Ribble Valley Borough Council
Housing & Development Control

Your ref: 3/2023/0153
Our ref: D3.2023.0153
Date: 31st March 2023

Application no: **3/2023/0153**

Proposal: **Proposed erection of a 66 bed care home (use class C2) for elderly people with associated parking, access, landscaping and associated ground works, alongside the erection of 3 dwellings following the demolition of nos. 23-25 Old Row.**

TITLE  
BIN STORE DETAIL

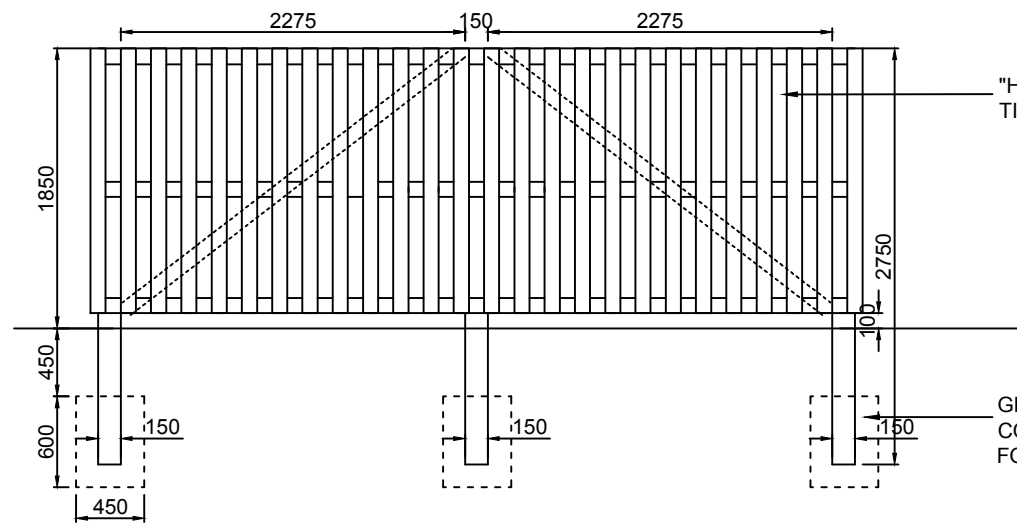
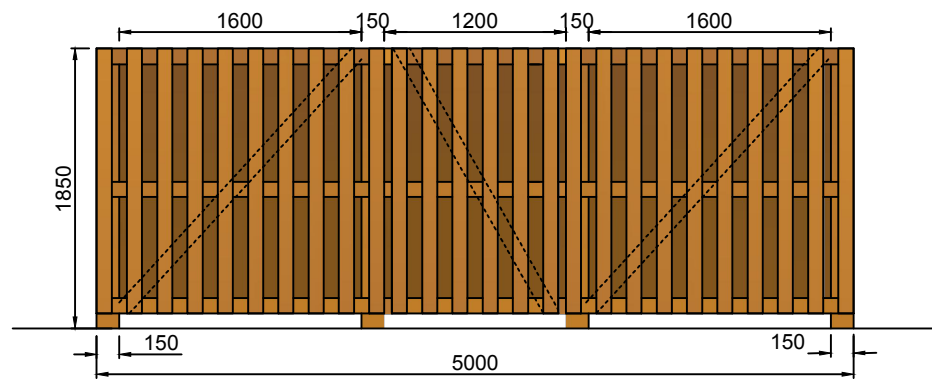
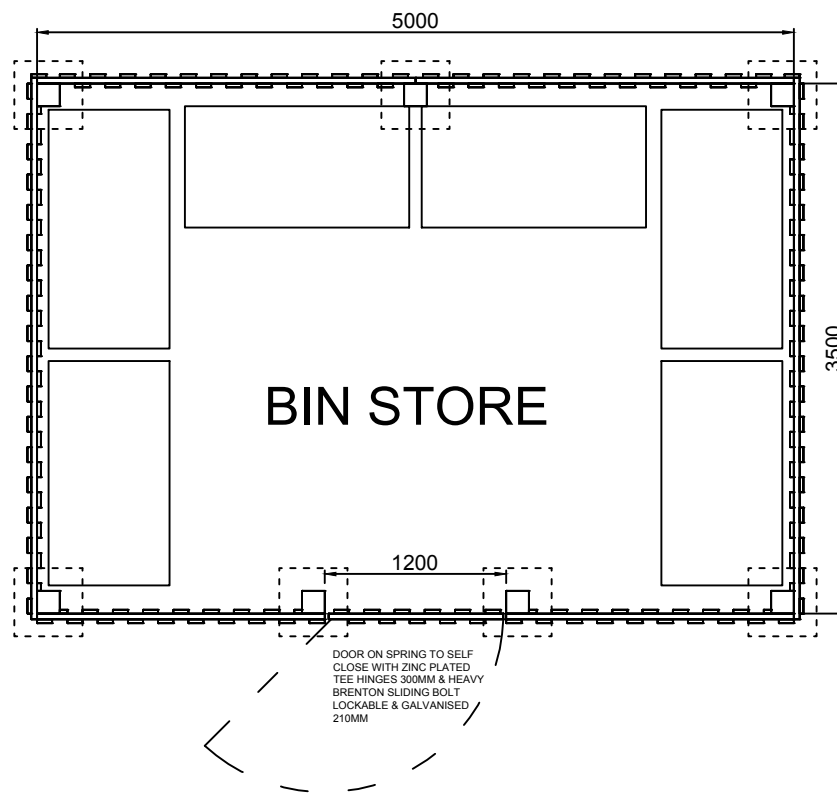
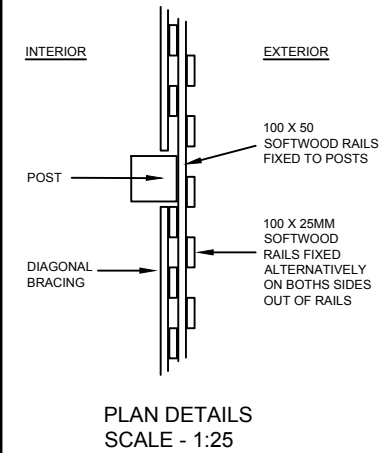
The LHA have further reviewed the footway adjacent to the bin store, as shown on the drawing, and require tactile paving to be provided when the footway terminates adjacent to the internal road serving the car park and on the footway opposite. This location can then be used as an informal pedestrian crossing point to the main entrance of the care home.

The LHA are also aware that the site will provide sheltered motorcycle spaces which will be located adjacent to the bin store and cycle storage facilities located adjacent to the main entrance. The LHA welcome these additions to the site.
